**Planning Department  
Transportation Development Services**

March 17, 2015

**Re: La Cumbre – Patio Addition**  
**3313 Girard Blvd., NE**  
**Traffic Circulation Layout**  
Engineer's/Architect's Stamp dated 3-6-15 (G16-D103)

TRAFFIC CIRCULATION LAYOUT EXISTING
14001
AS001

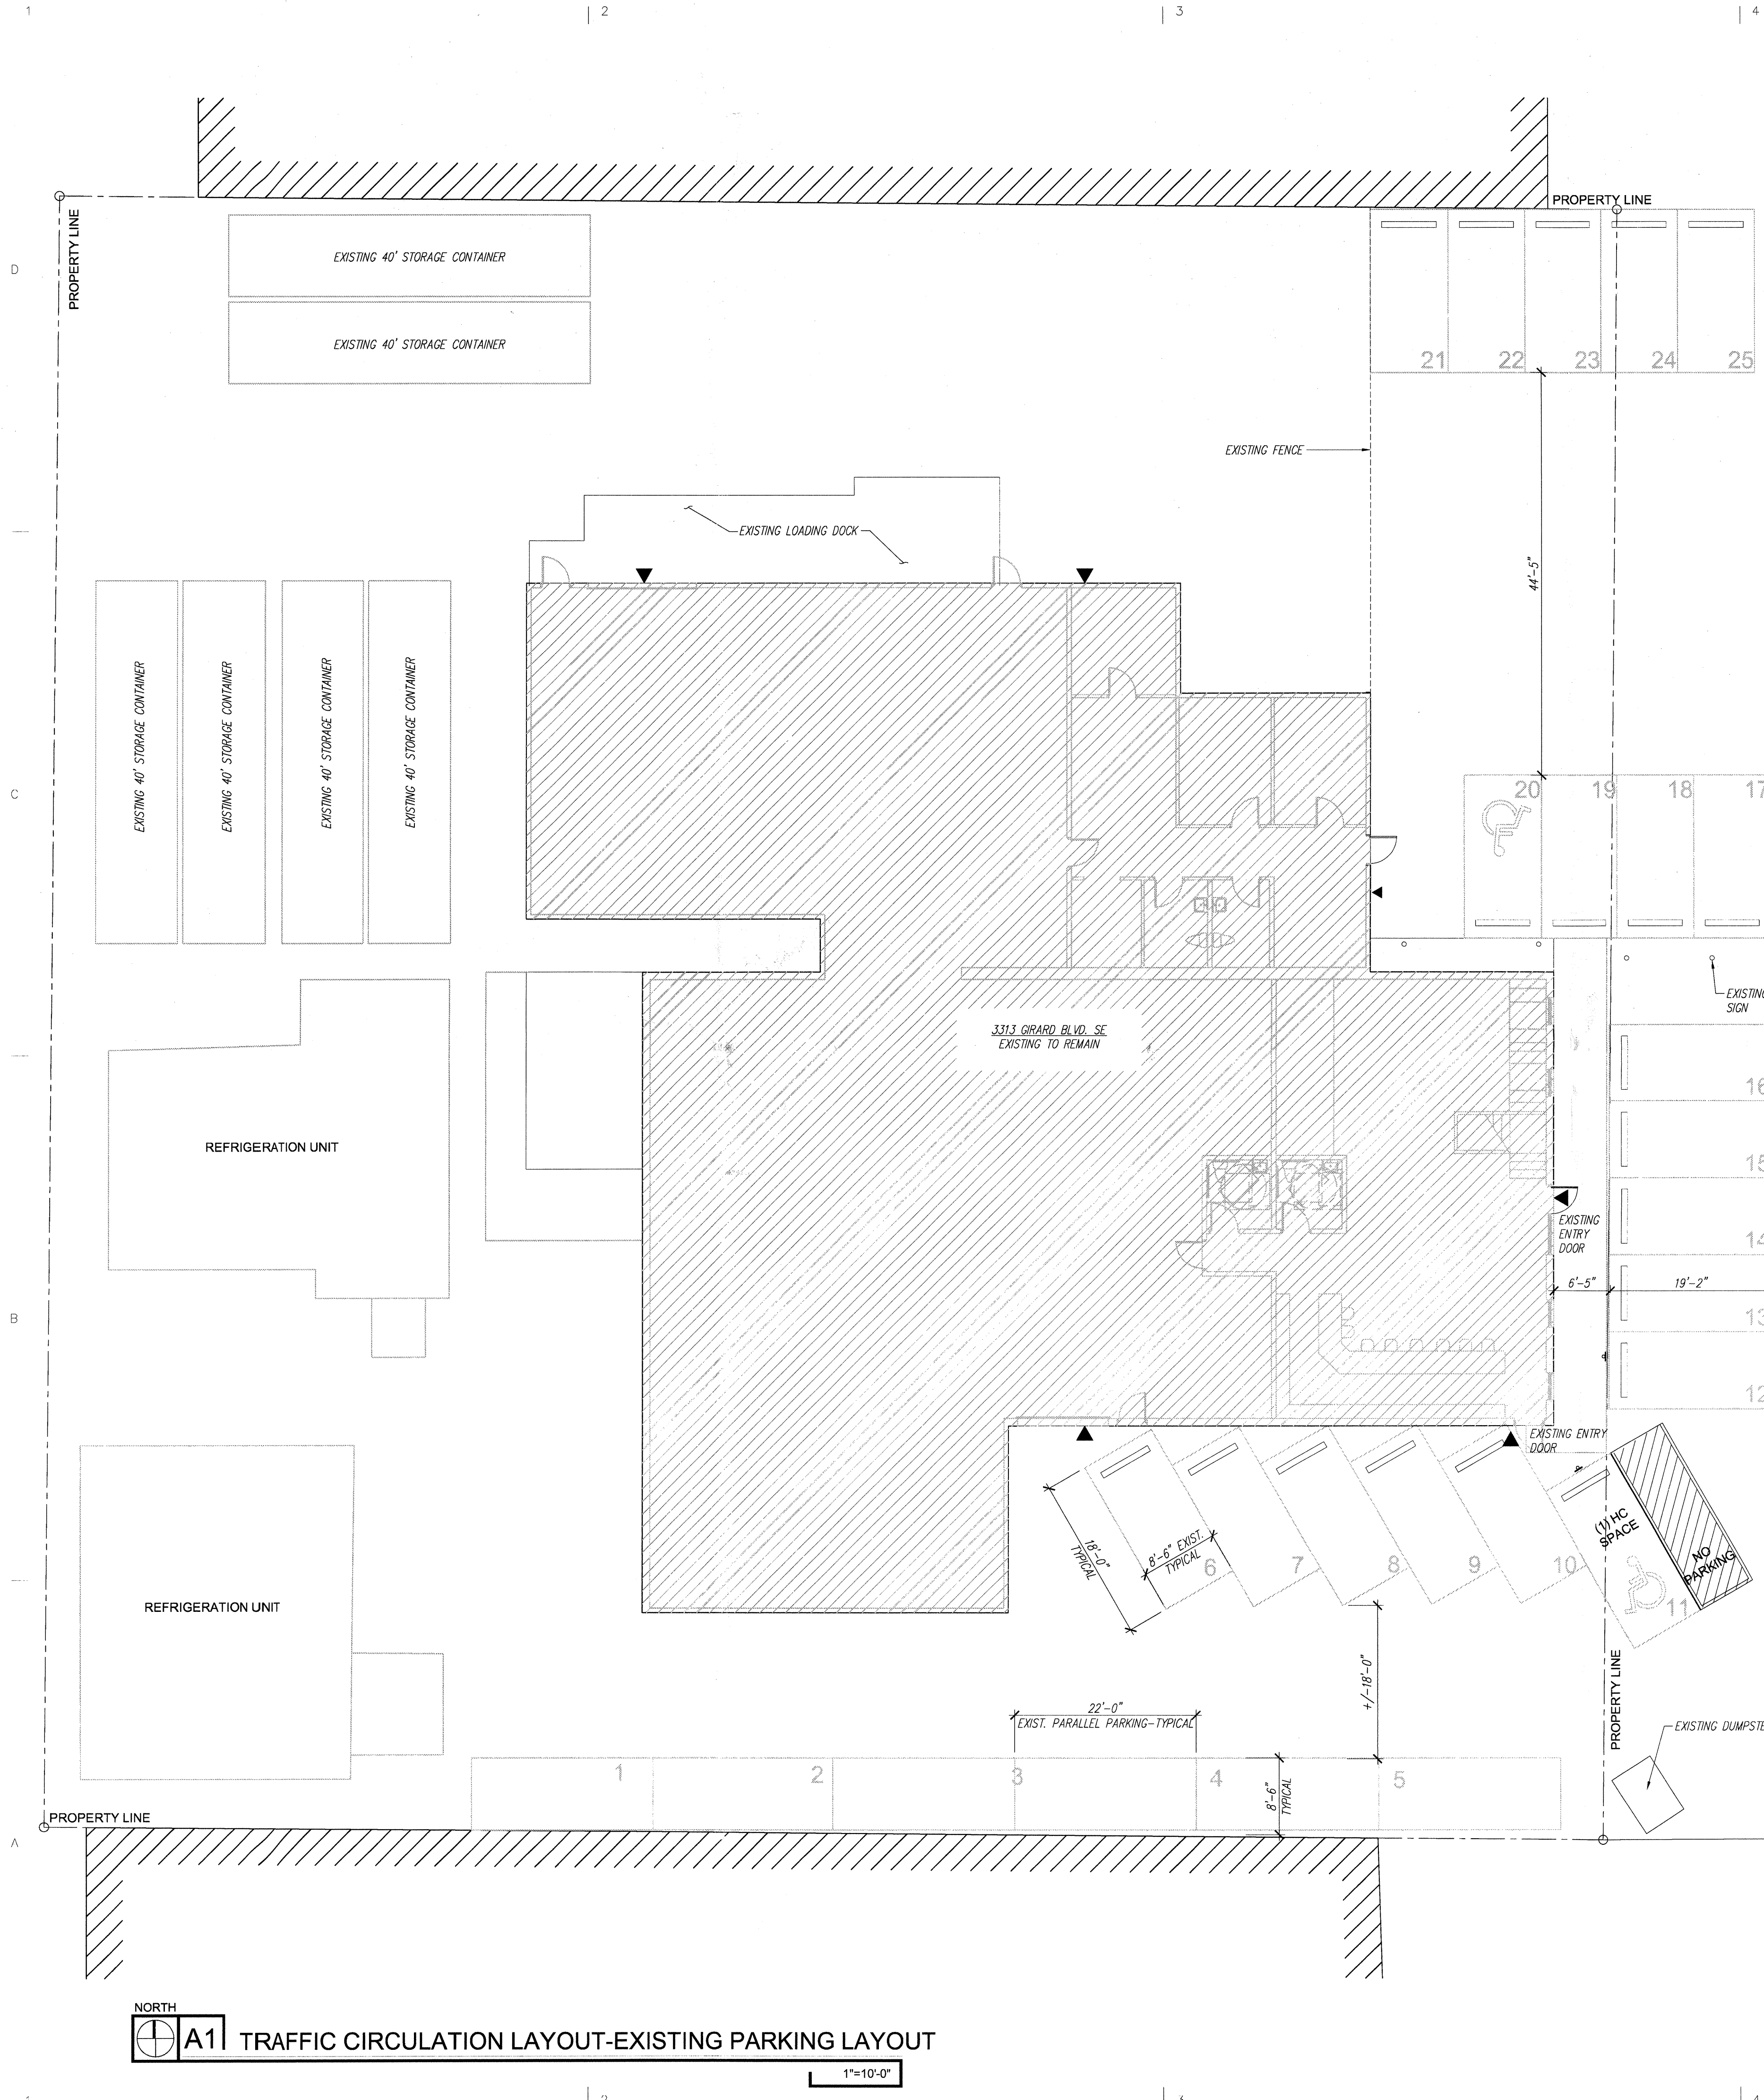
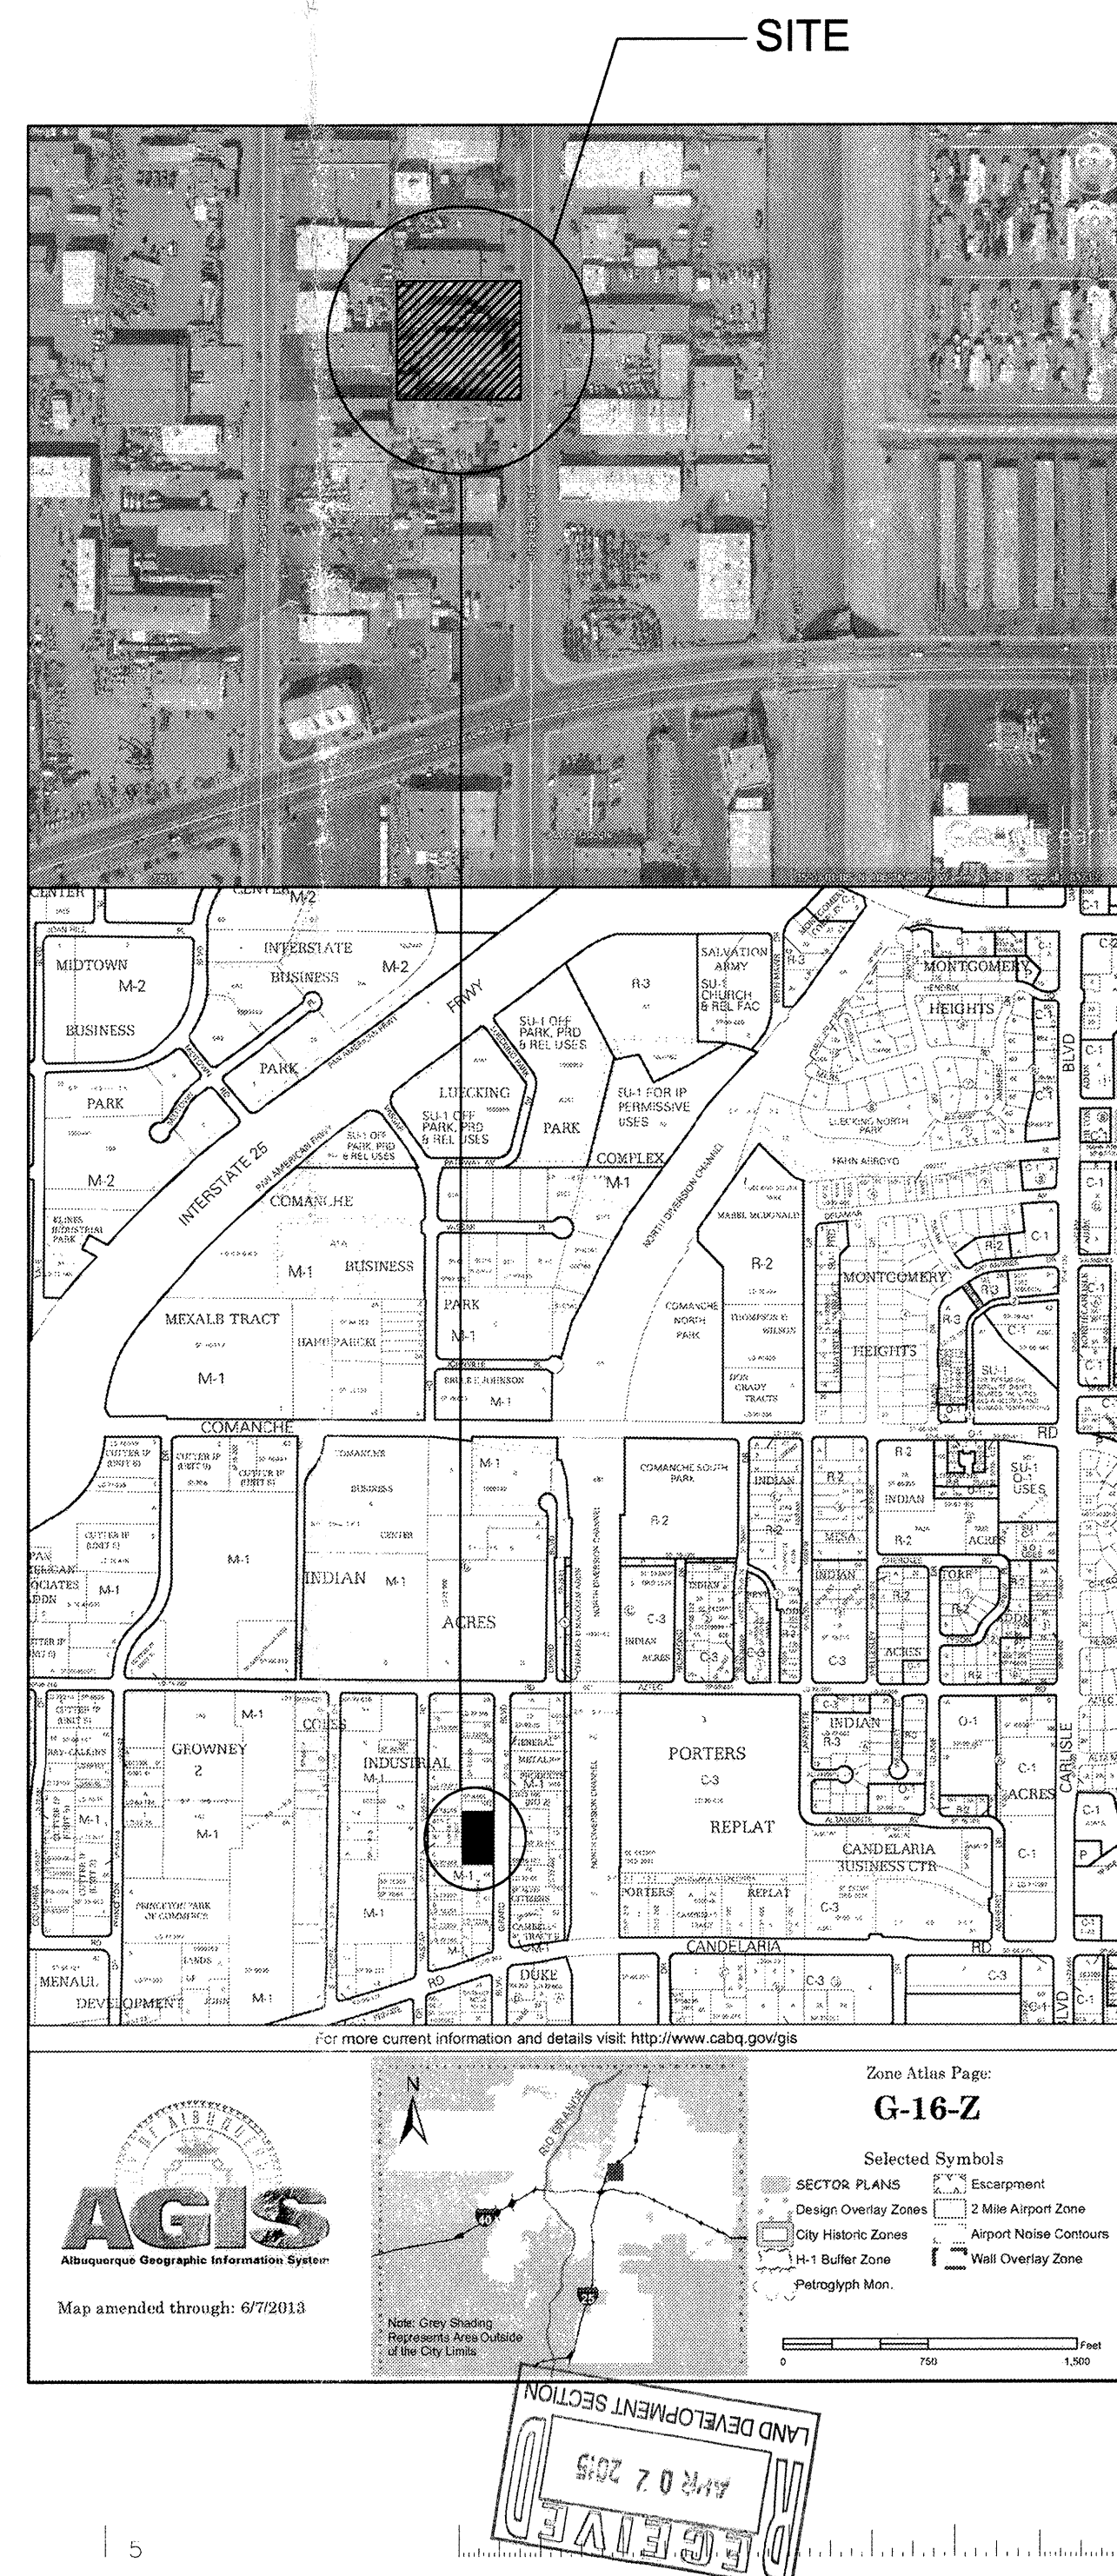
1. Please identify all existing doors, pedestrian walkways, sidewalks, curbs, drive pads, walls and anything that influences the parking and circulation on both sites. Provide detail of existing pedestrian walkways and doors with dimensions.

2. Identify the right of way width, medians, curb cuts, and street widths on Girard - Blvd. for both locations.
3. Please provide detail of existing north drive pad and railing. It appears that the drive pad will need to be extended for the proposed parking and that the railing will have to be removed from blocking portions of existing drive pad.

4. Please list the width and length for all parking spaces for the 3313 Girard Blvd. location. Parking spots # 21 and 22 are not dimensioned. It appears that the proposed throat length distance from the handicap parking spots and parking space # 19 does not meet the minimum distance of 24-Ft.

7. A five-foot keyway is required for dead-end parking aisles. It appears that the parking on the northwest corner of the building would be considered a dead-end parking. Bollards might be beneficial to protect the existing Silo notated on the drawing.

8. Please provide detail of existing pedestrian walkways, gates and handicap access to entrances. Please dimension distance between bumper stops and building and or walkway.

9. Per the DPM, a 6 ft. wide ADA accessible pedestrian pathway is required from the public sidewalk to the building entrances. Please clearly show this pathway and provide details.

10. Per the DPM, a 6 ft. wide ADA accessible pedestrian pathway is required from the HC parking stall access aisles to the building entrances.
11. Provide a min 6" or max 8" high concrete barrier curb or other acceptable barrier between landscaping and parking areas and/or drive aisles.
